CITY OF PORTLAND

BUILDING PERMIT

Job ID: 2011-07-1813-ALTCOMM

has permission to Make alterations for legalization of dwelling units, and upgrade owner apartment, new bathrooms. provided that the person or persons, firm or corporation accepting this permit shall comply with all of the provisions of the Statues of Maine and of the Ordinances of the City of Portland regulating the construction, maintenance and use of the buildings and structures, and of the application on file in the department.

26 BRACKETT ST.
 FLOOR PLANS 1/8" = 1'-0"
 for ASHLEY SALISBURY
 4/11

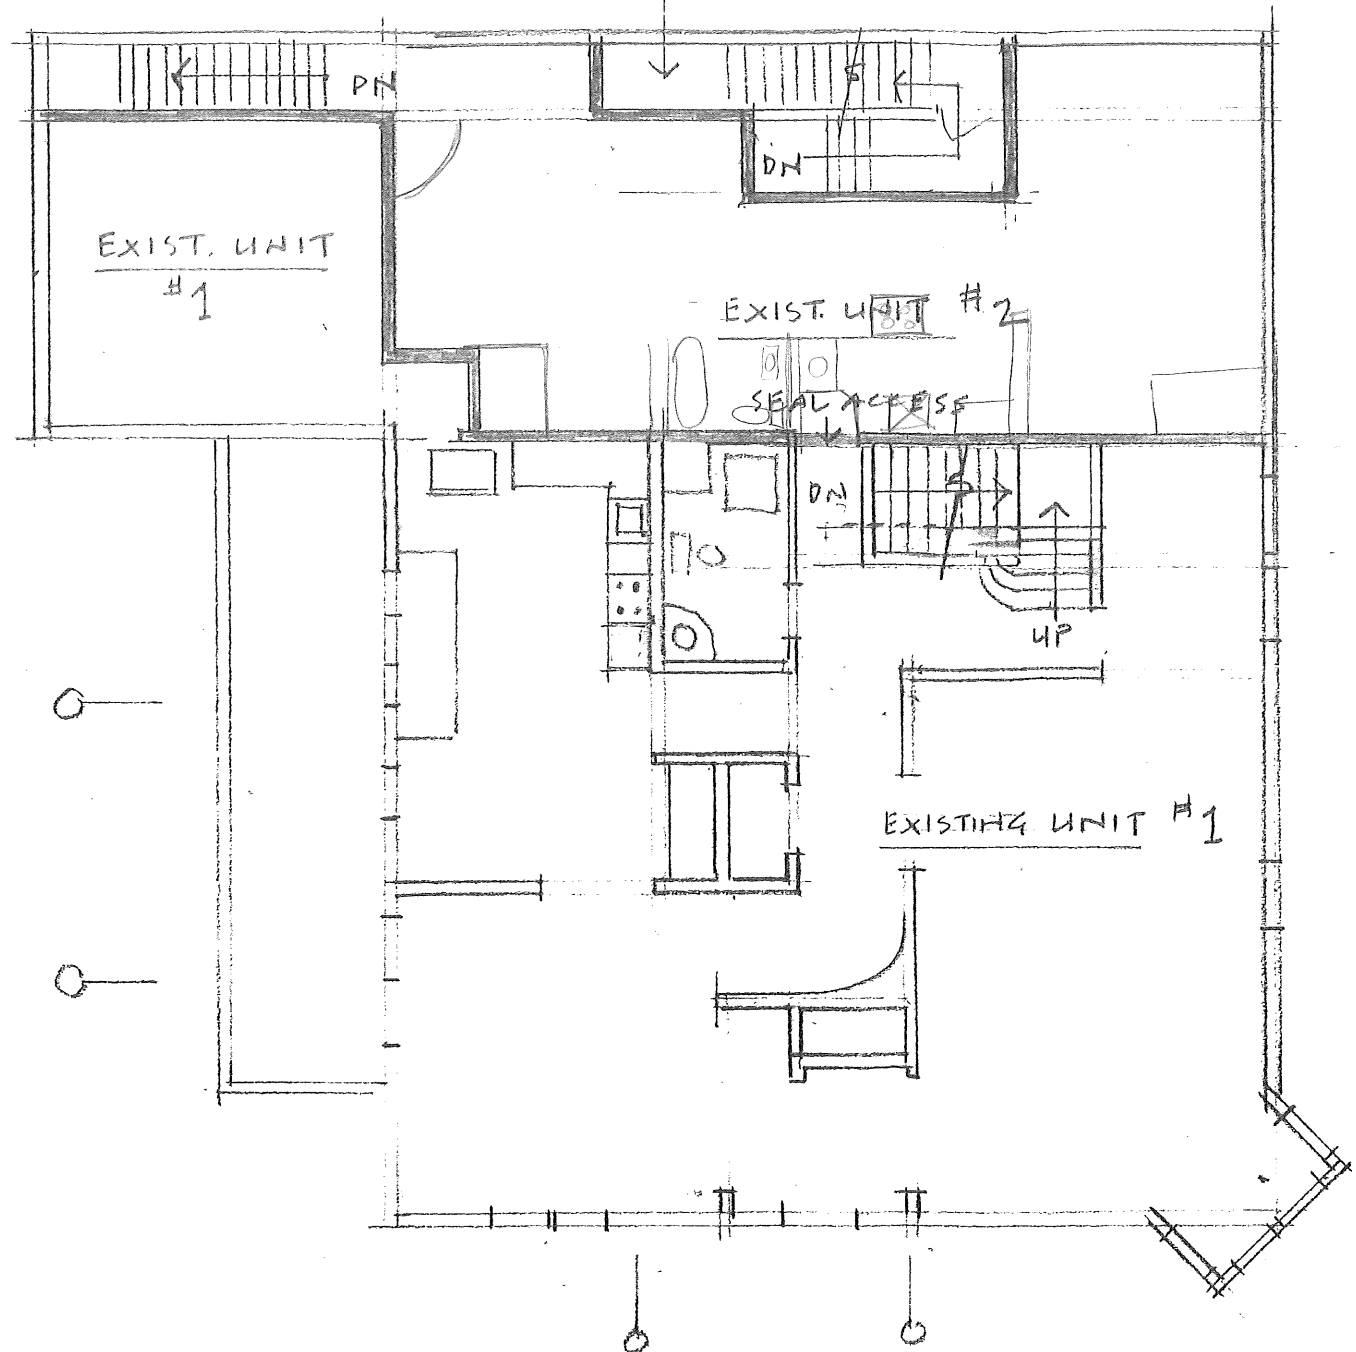
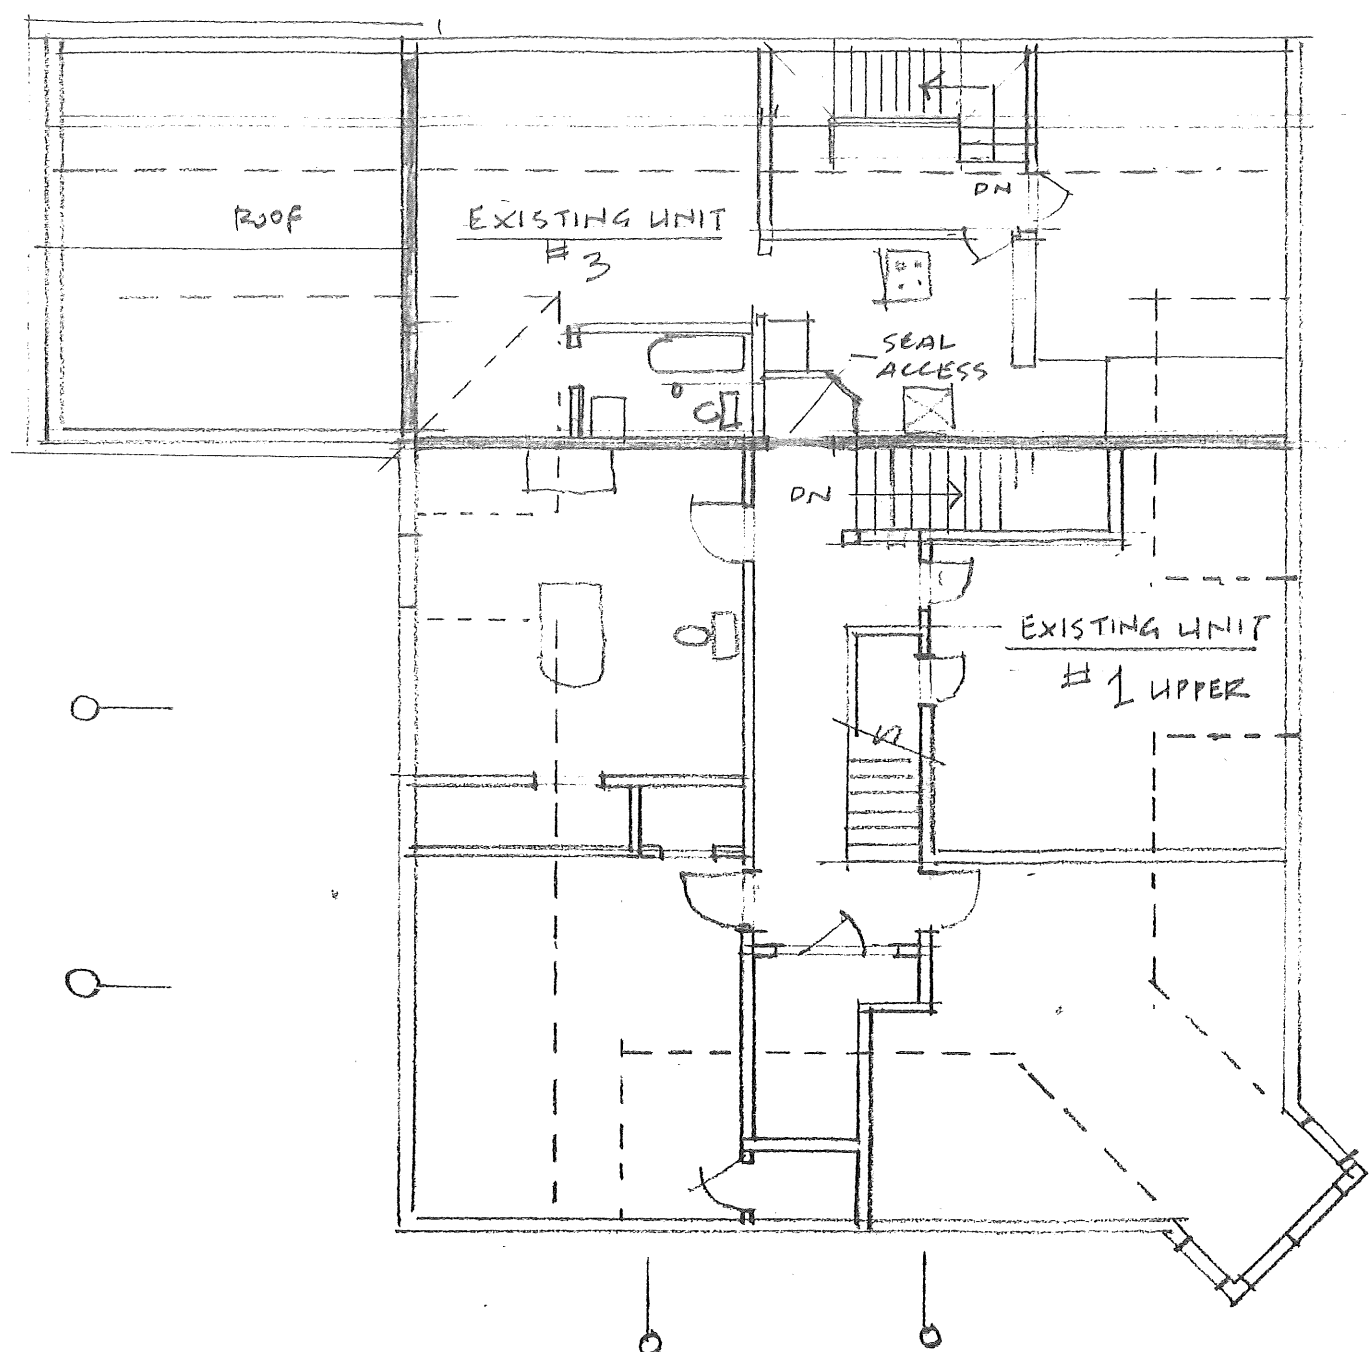
- 6'8" headroom at center of toilet bowl in 1/2 bath, ventilation in bathrooms, 6'8" headroom at steps to platform tub in master bath, steps to have min. tread of 10" and max. rise of 7-3/4"

- Tempered window, or treatment on existing window at bathtub, specifications required
 - Other than infill of existing doors, where covering over bare studs, insulation and resilient channel required

4. This permit is approved per IEBC Sec. 705.3.1.1 for means of egress for a single exit from residential apartment dwellings based on travel distance and stories. See plans.
